Letter of Intent

Bent Grass Residential Filing No 2

September 03, 2019

Markup Summary 9-18-2019

CHANNEL PLAN & PROFILE

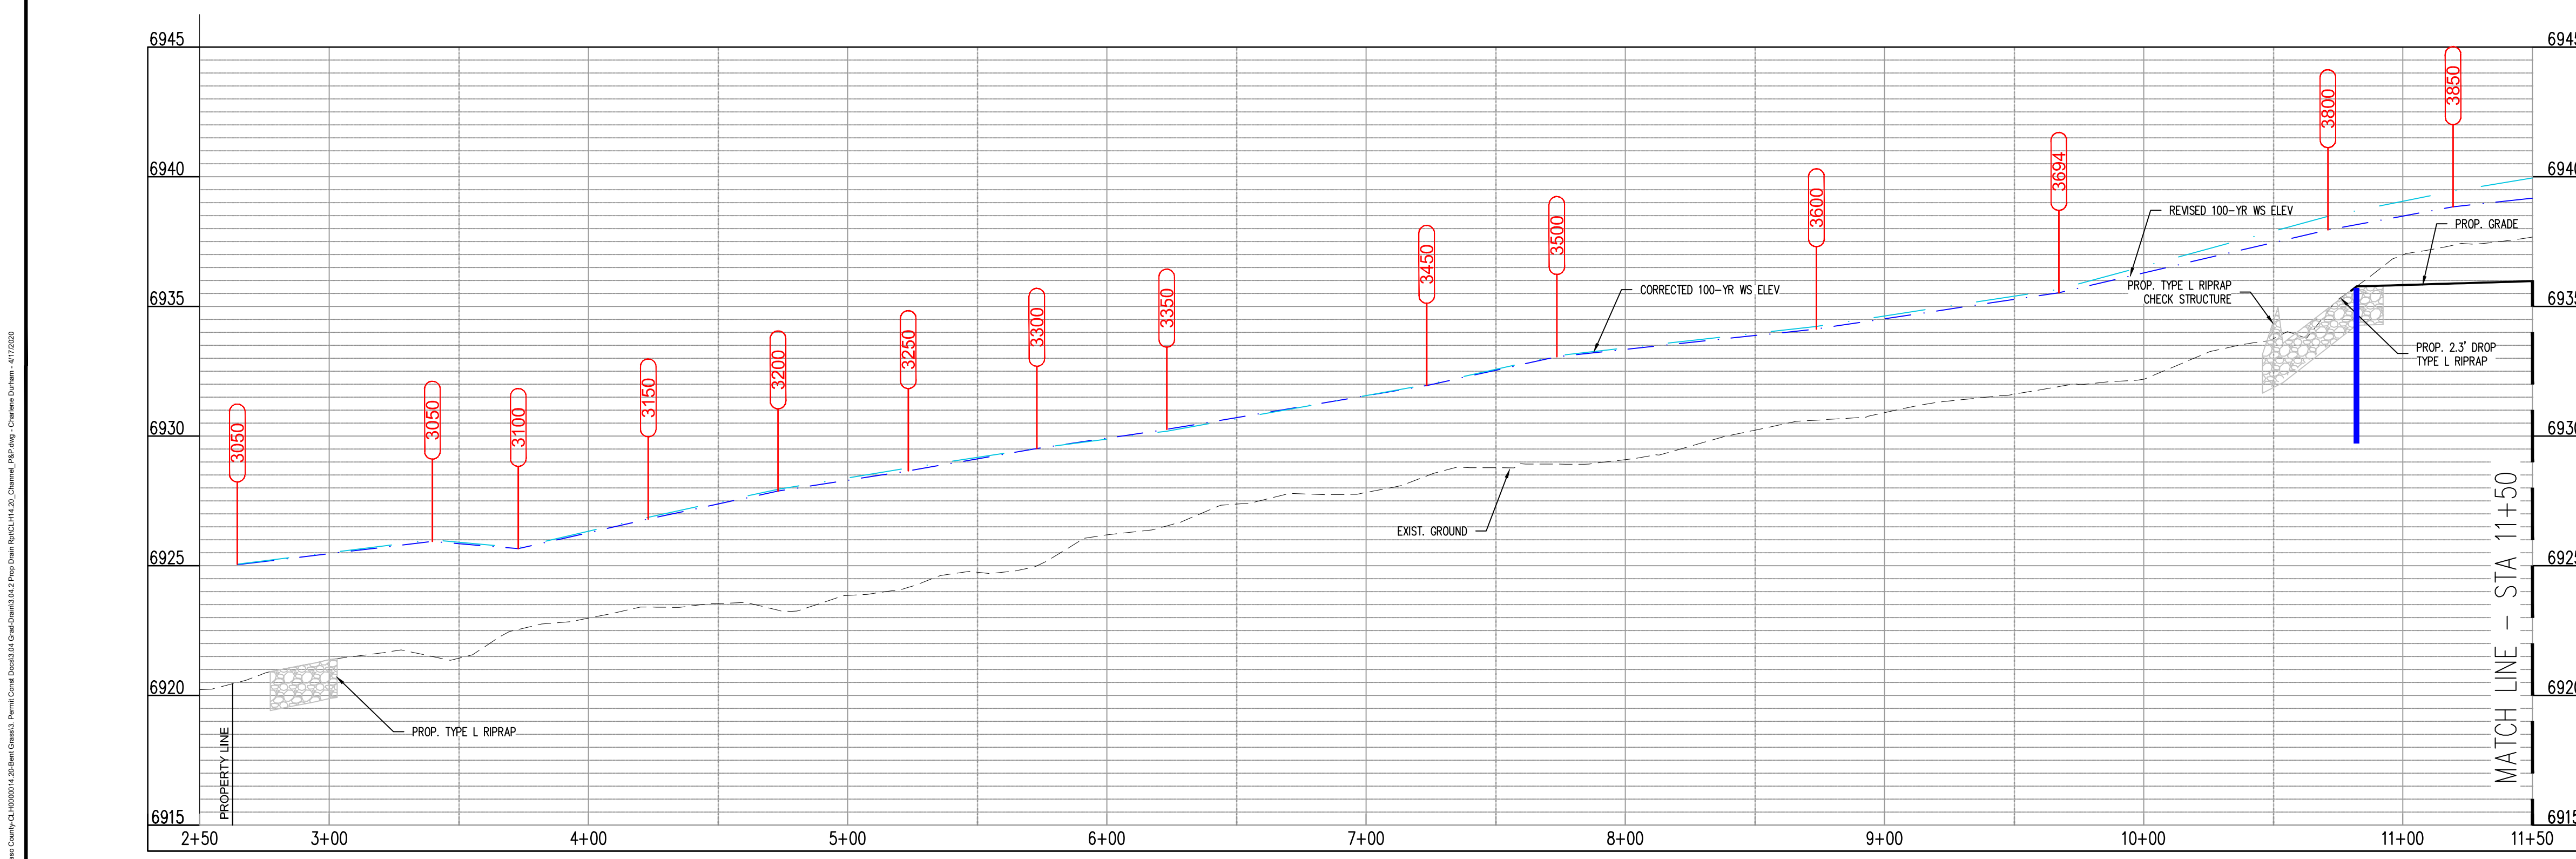
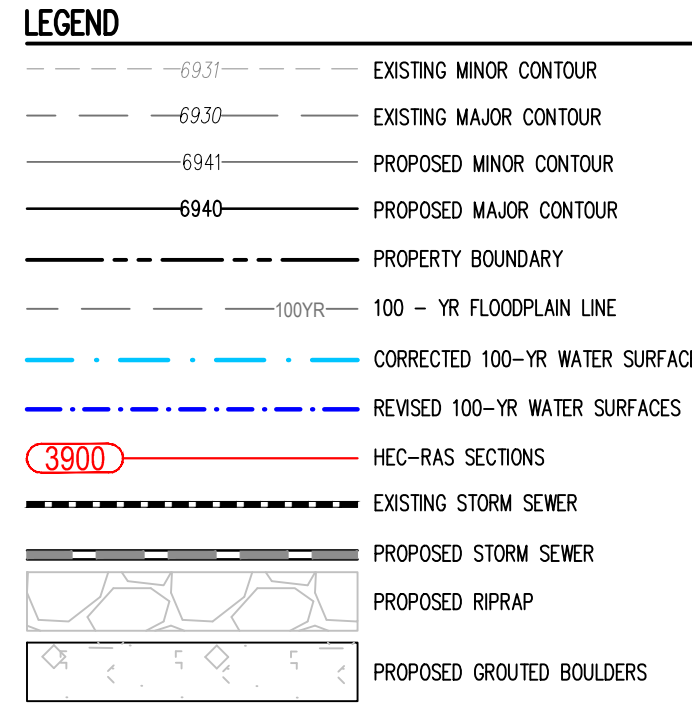
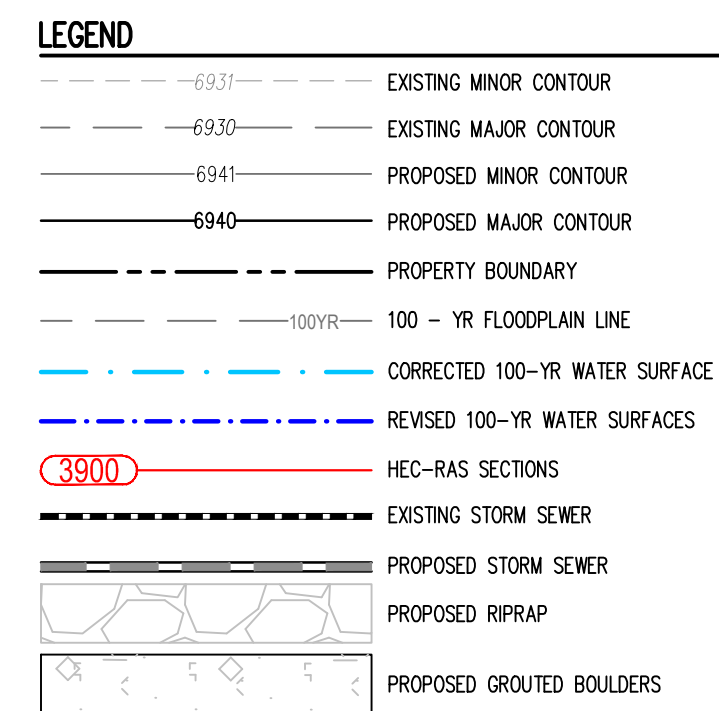
There are two channels within this plat area??
please place in drainage easements if that is the case

where is this located? The PC and BoCC have no idea what and where pond WU is

verify it is the off site improvements for the
this drainage report since you are not
putting a pond within plat

OVERALL BOUNDARY & EASEMENTS MAP

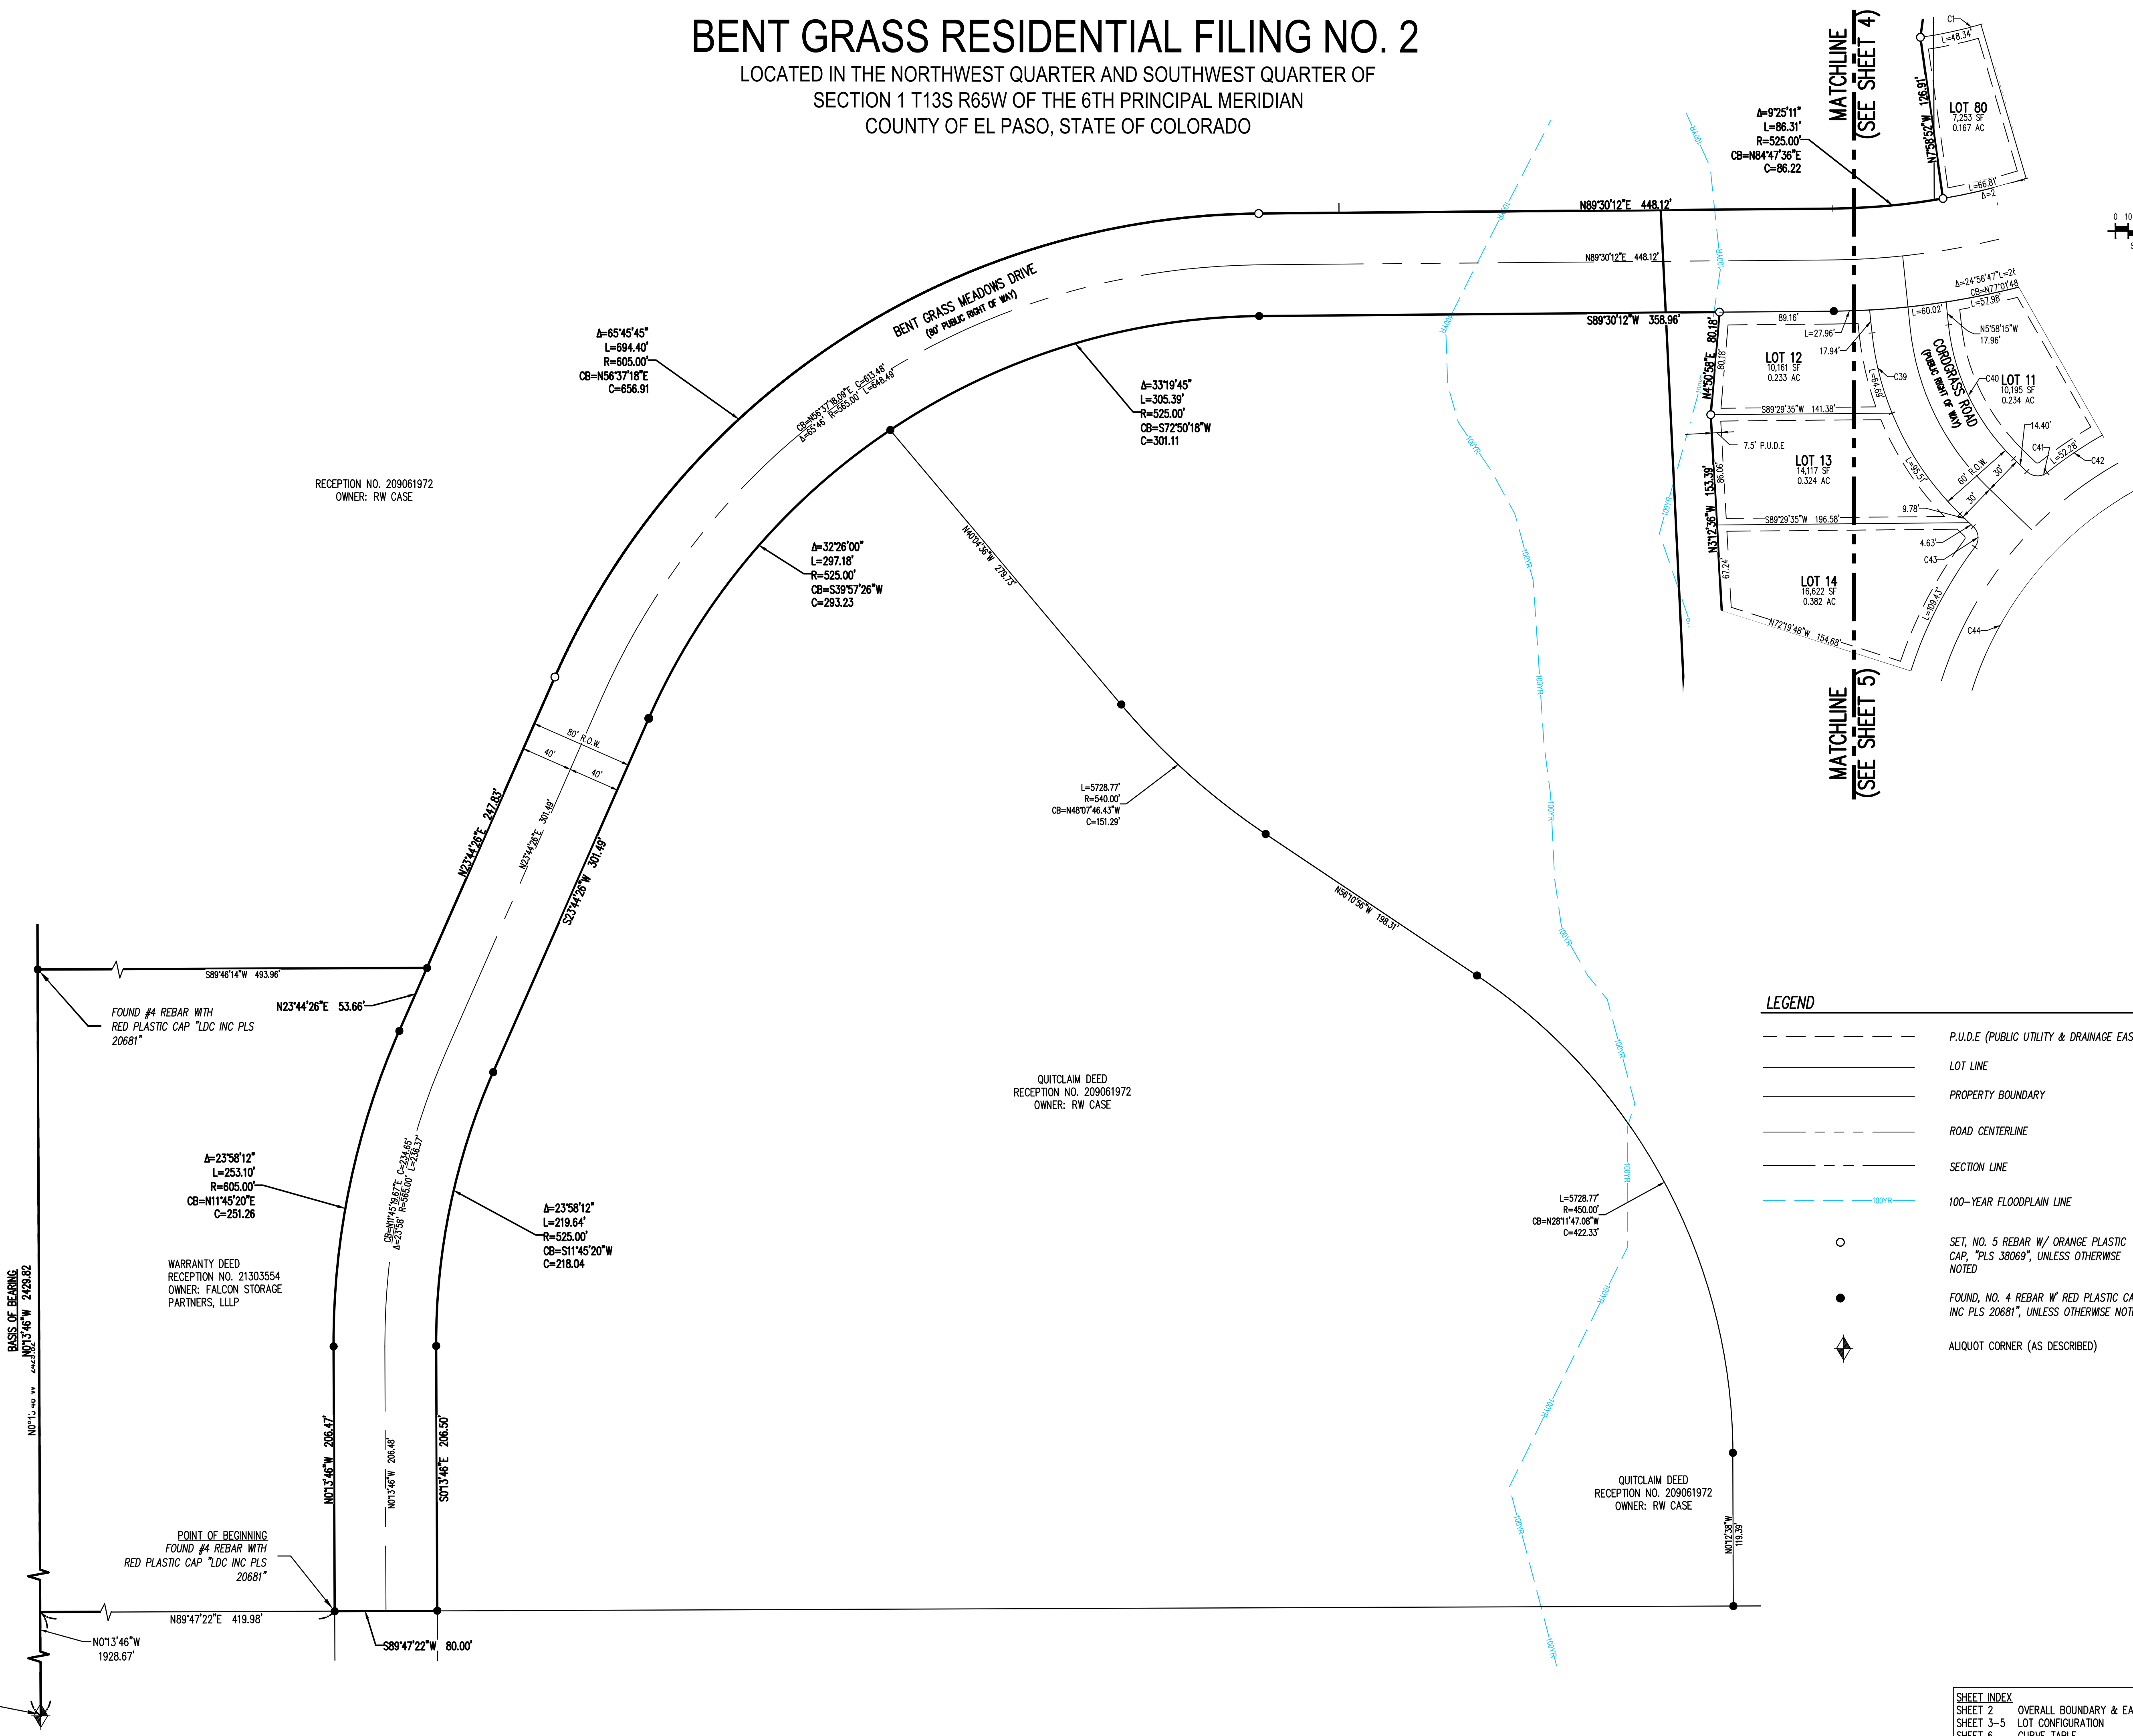
The water wastewater comt is for 121 lots. 177 as indicated in the application form, the LOI states 181 lots; The plat numbering is so confusing - its unknown how many lots are proposed

How many Lots? tracts? Acreage in ROW? Water sufficecny? any deviations requested?
